**KIRKLEES COUNCIL
TOWN AND COUNTRY PLANNING ACT 1990
HIGHWAYS DEVELOPMENT MANAGEMENT**

PLANNING REF 2017/60/90207/W0/MW
CATEGORY Small Major

PROPOSAL OUTLINE APPLICATION FOR
ERECTION OF B1 LIGHT INDUSTRY

LOCATION THONGSBRIDGE MILLS
MIRY LANE
THONGSBRIDGE
HOLMFIRTH
HD9 7RW

ARTICULATED VEHICLE TRACKING

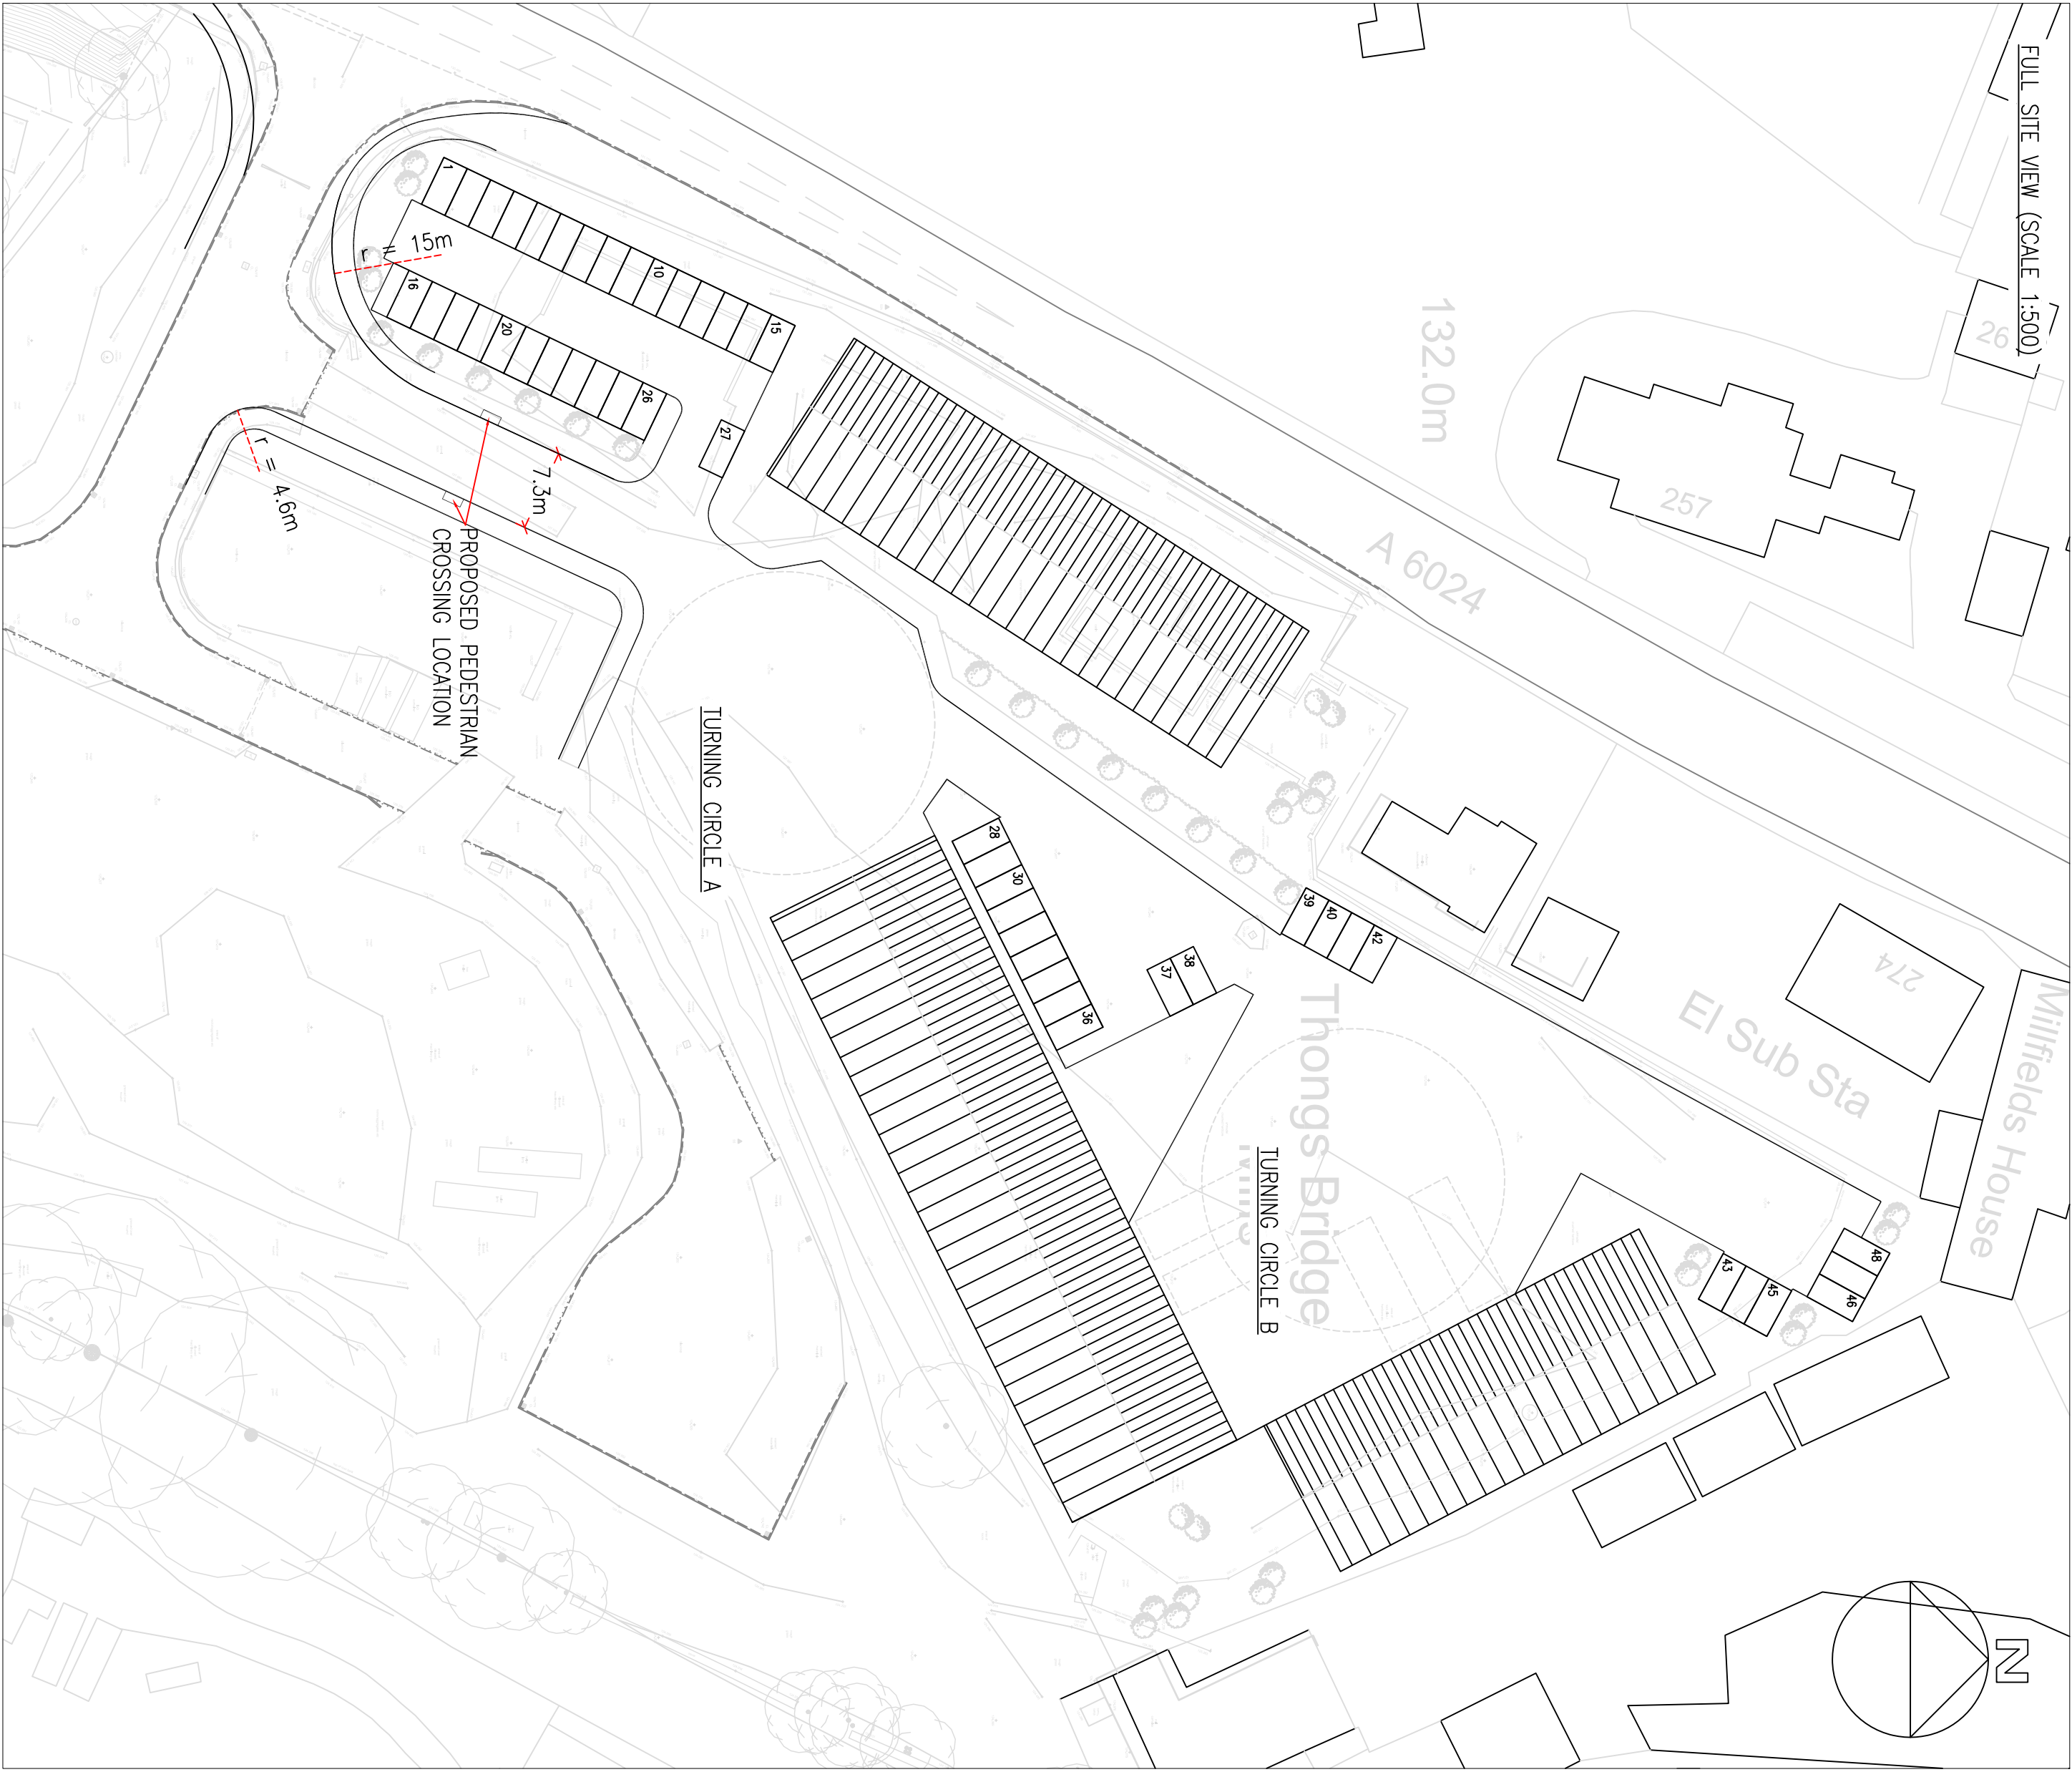
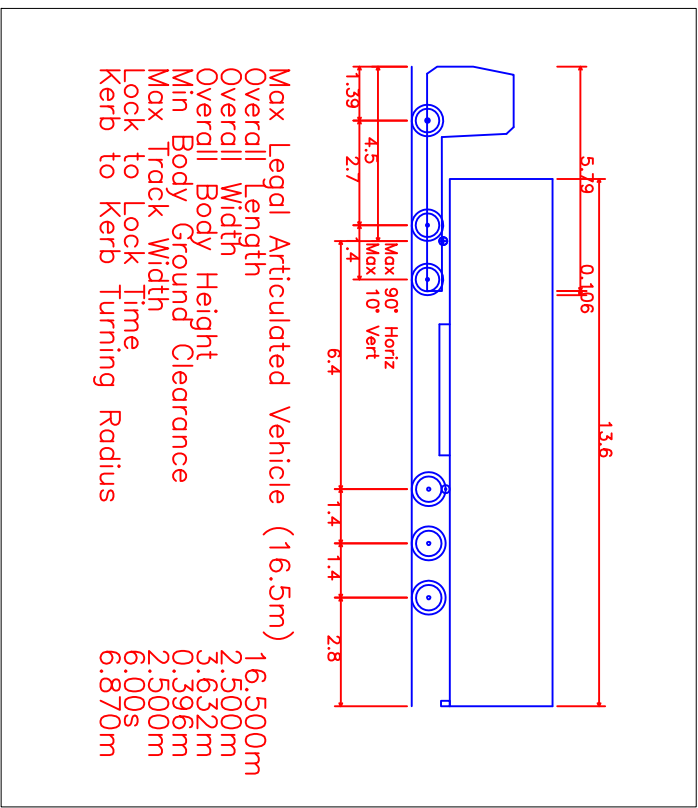
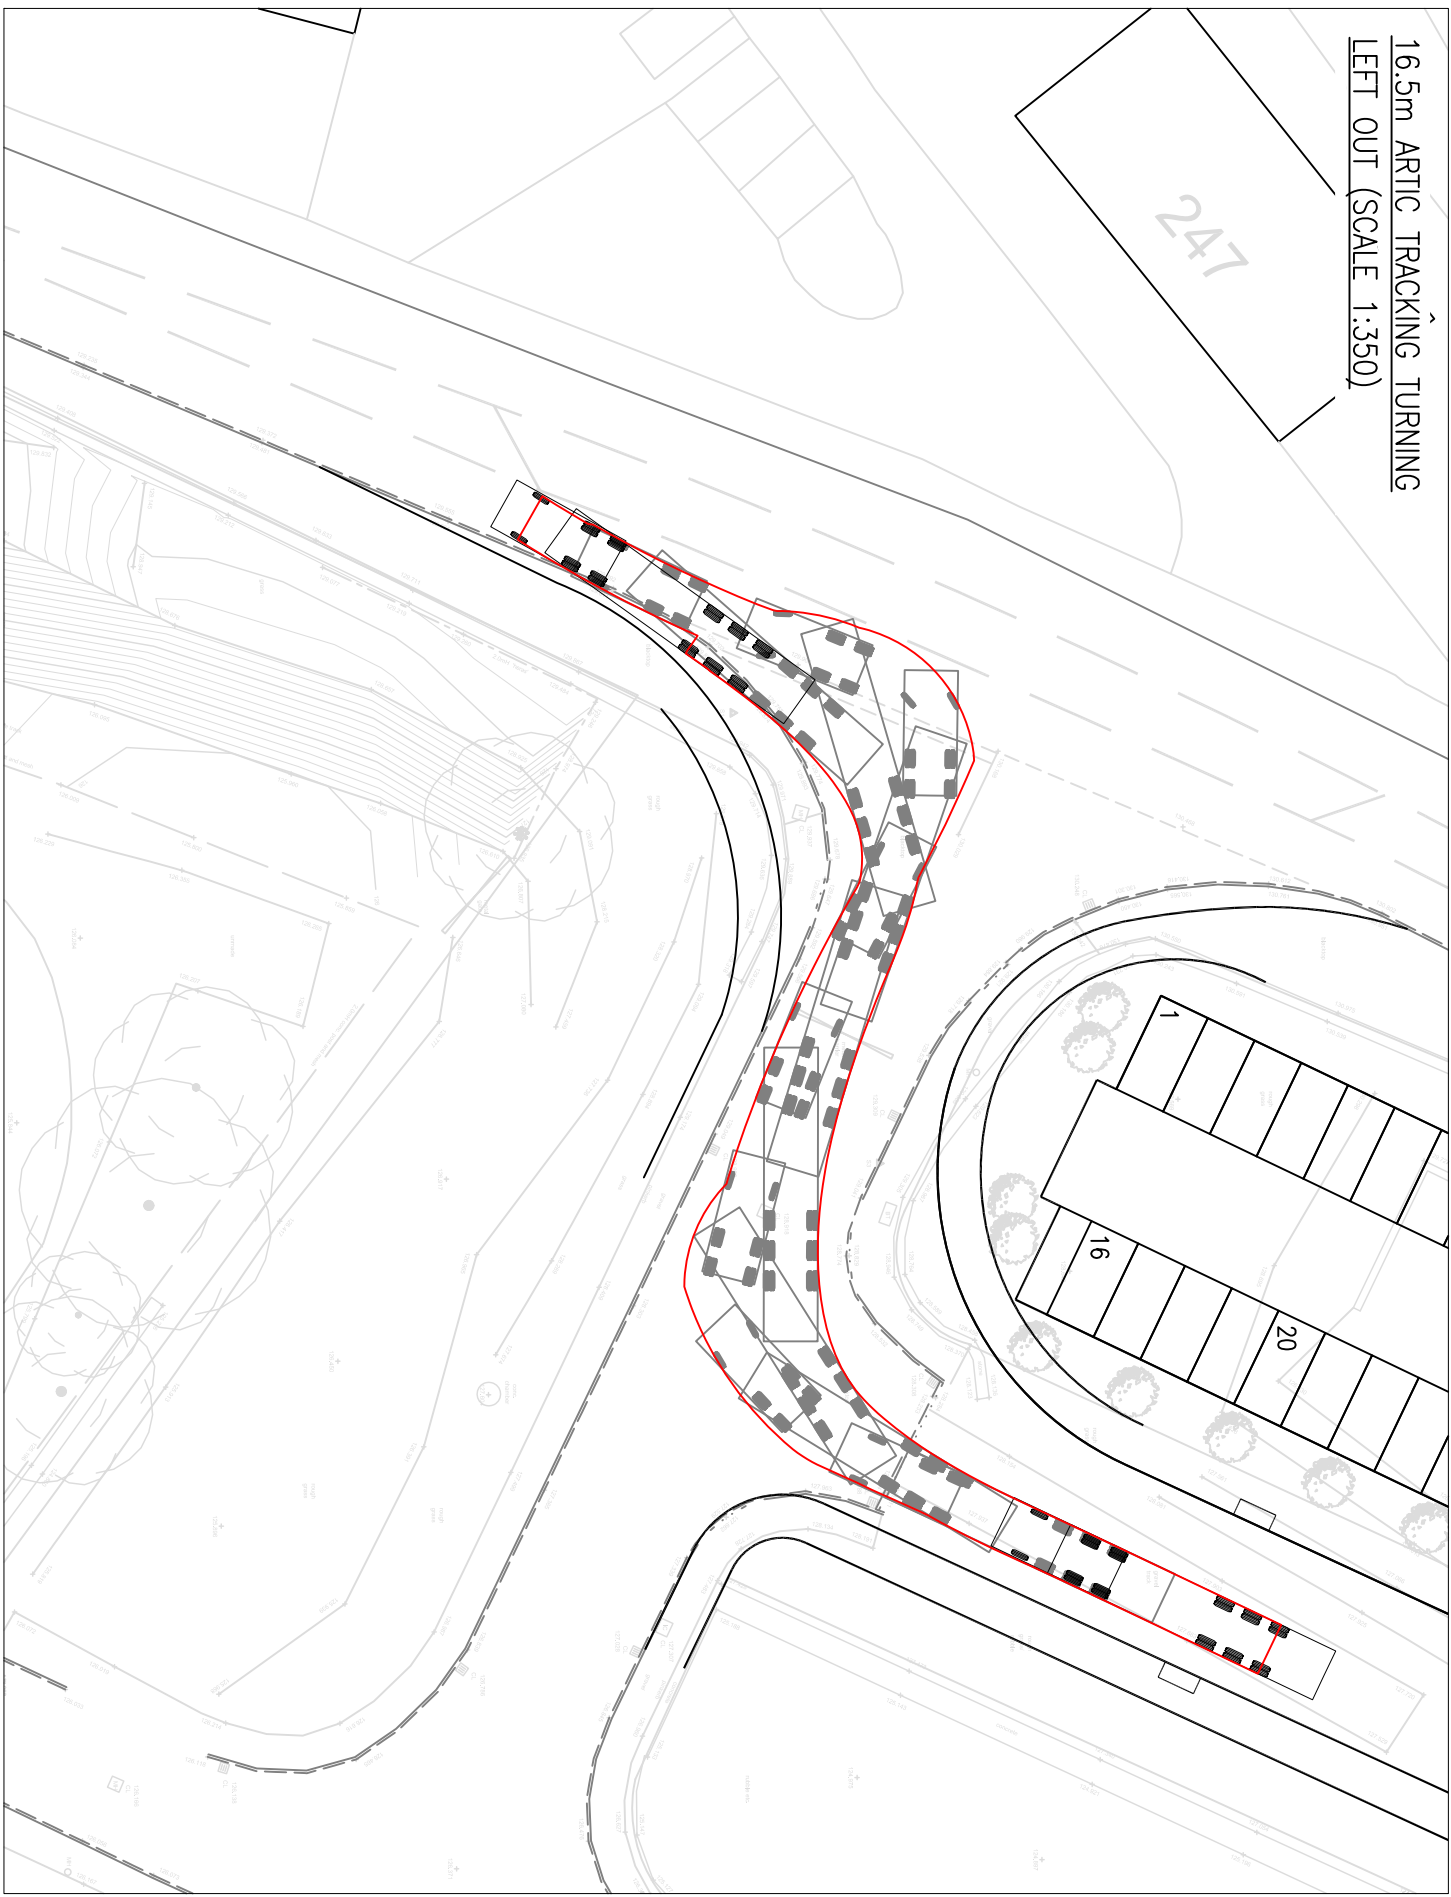
The applicants revised plan number 1212-101 rev B (articulated vehicle tracking) which shows that a 16.5 metre articulated vehicle can undertake all movements satisfactorily. Whilst this plan is considered acceptable Highways have concerns regarding the increased width of the access onto Huddersfield Road and the implications for pedestrian. A pedestrian traffic island is therefore considered necessary to assist pedestrian movements across the proposed widened access.

With reference to plan no 1212-101 rev B, the development shall not commence until a scheme detailing the provision of a widened and improved site access from Huddersfield Road including the provision of a pedestrian island, visibility splays, construction specification, surfacing, drainage, white lining and signing and kerbing and associated highway works together with independent Safety Audits covering all aspects of the work has been submitted and approved in writing by the Local Planning Authority. The development shall not be brought into use until the approved scheme has been implemented and thereafter retained throughout the lifetime of the development.
